SITE INFORMATION: CORRAL BLUFFS 10093745

GENERATOR INSTALLATION PROJECT 2160 BLANEY ROAD COLOADO SPRINGS, CO 80929

SHEET TITLE: GENERAL NOTES SHEET NUMBER: N-1

OVERALL SITE PLAN

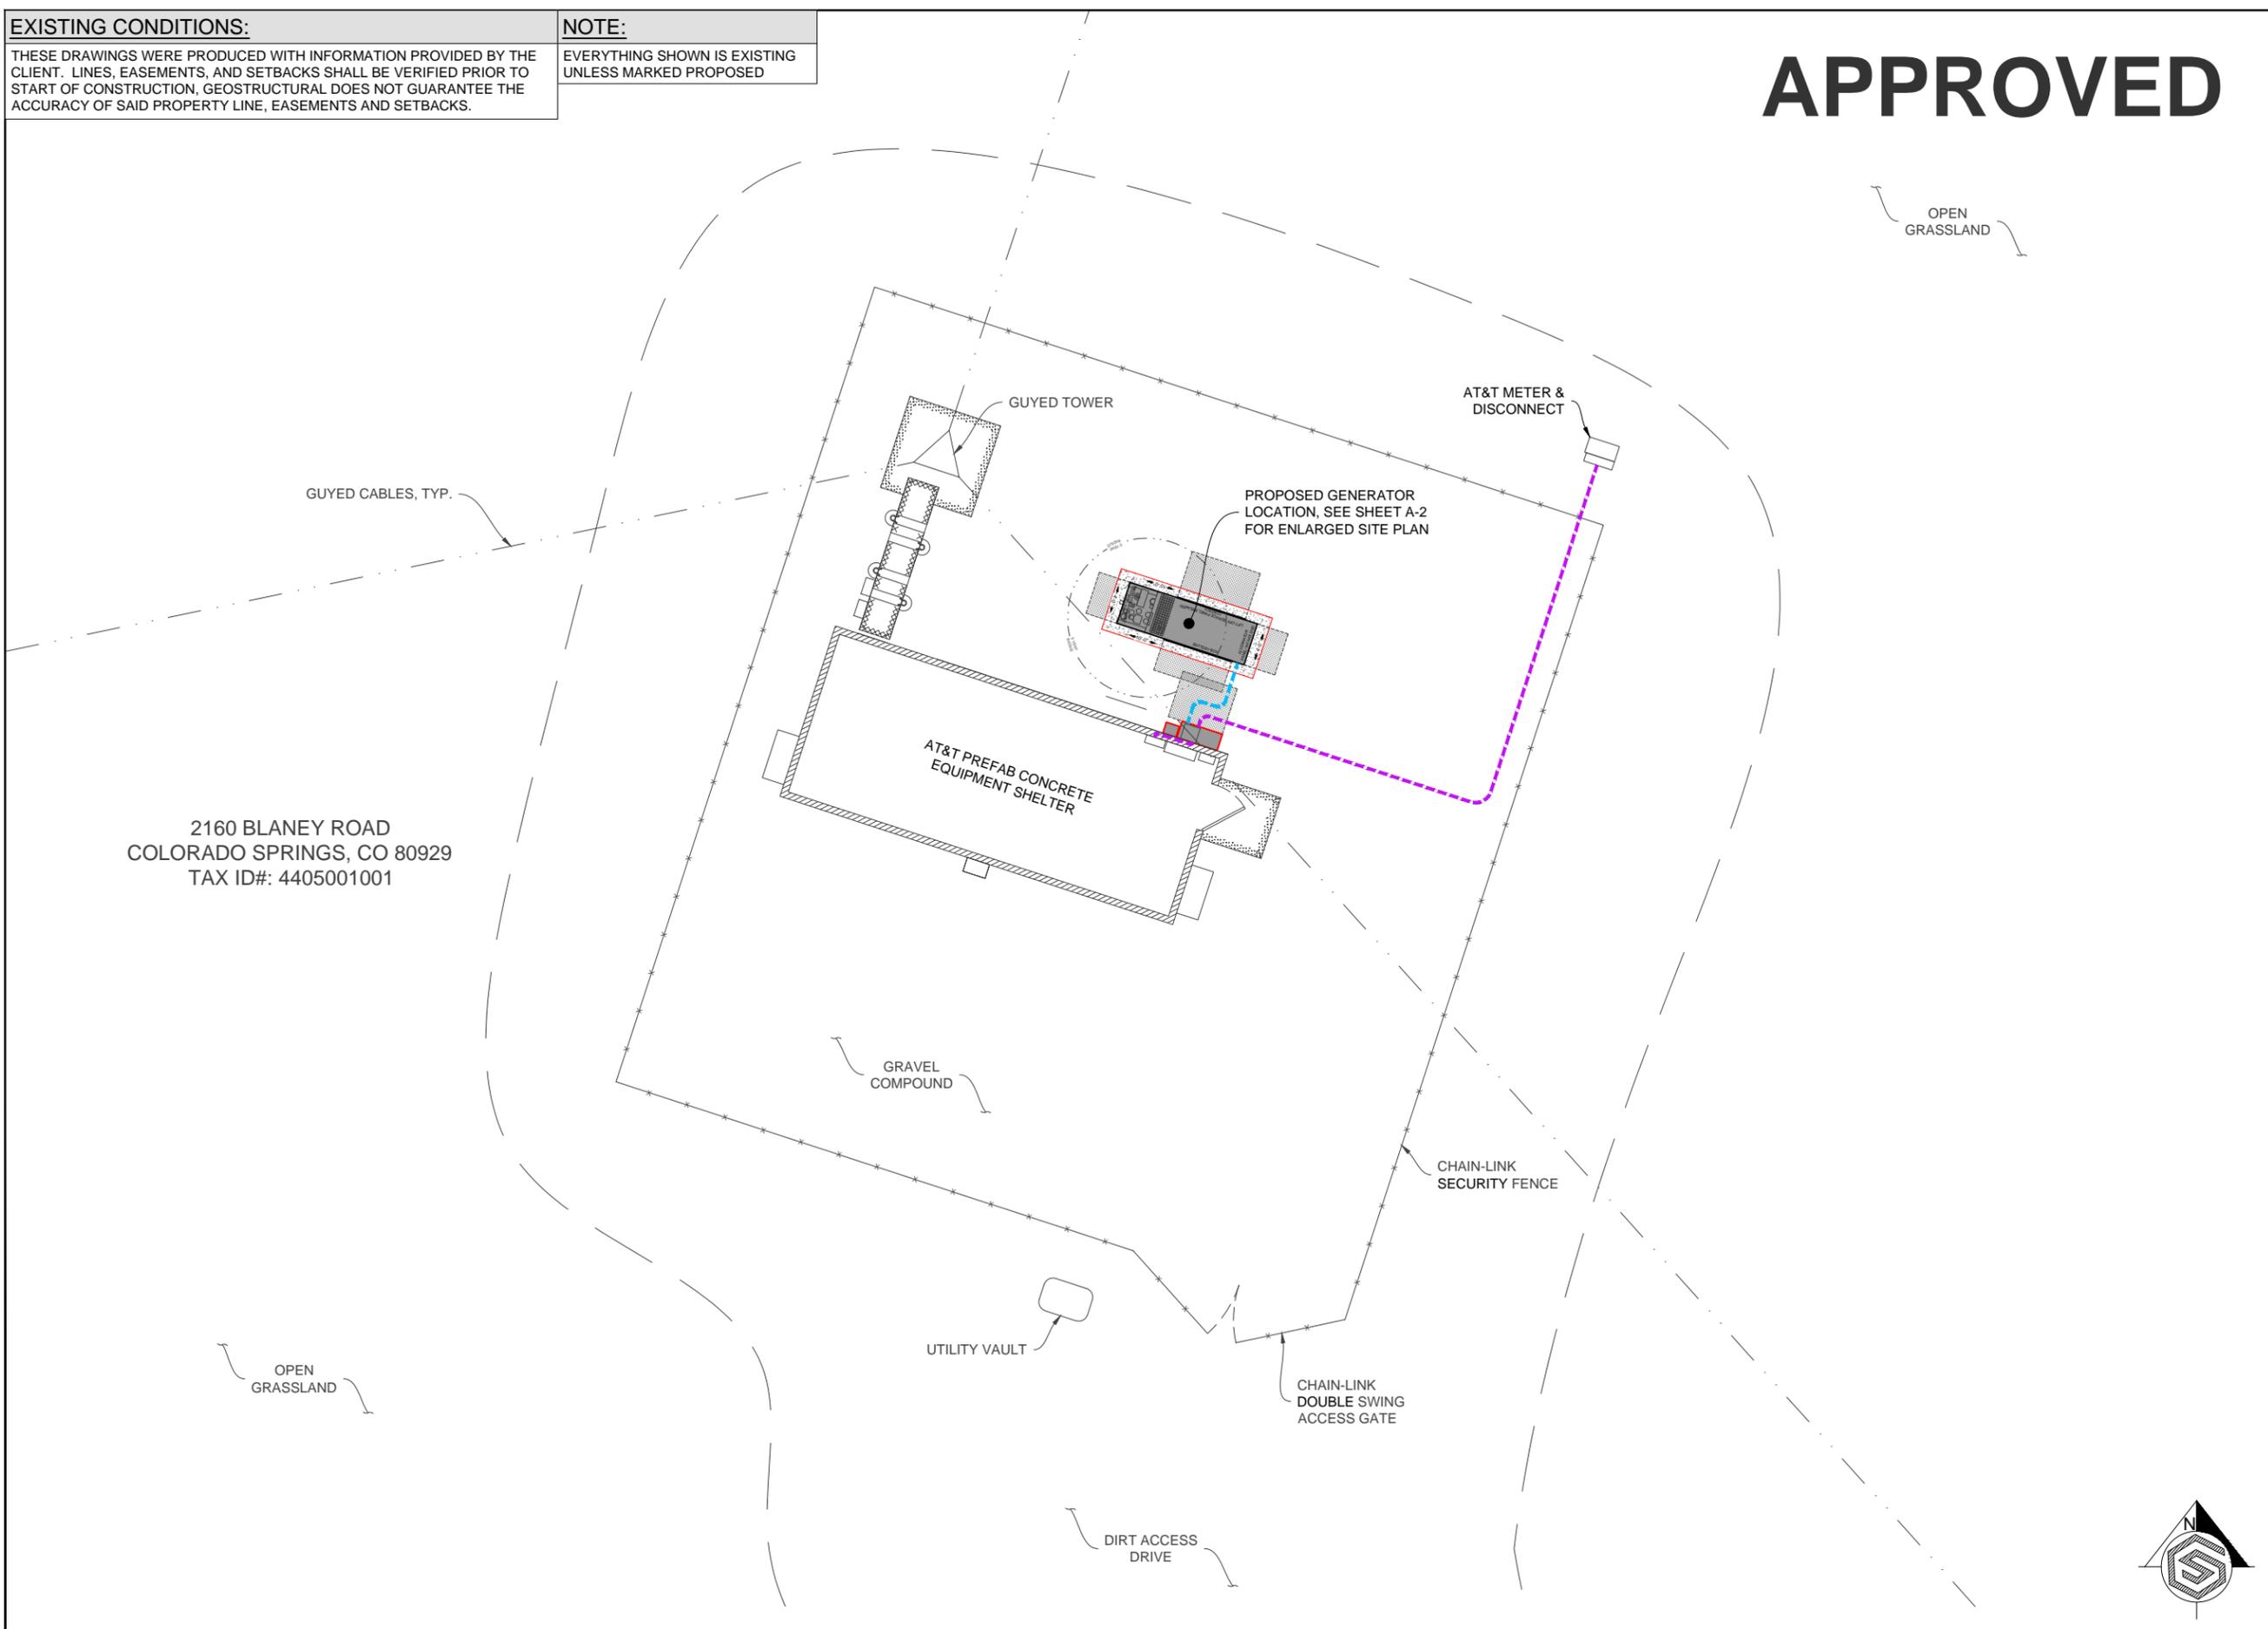
please include an image with the whole property outlined and the area leased for the tower is also outlined.
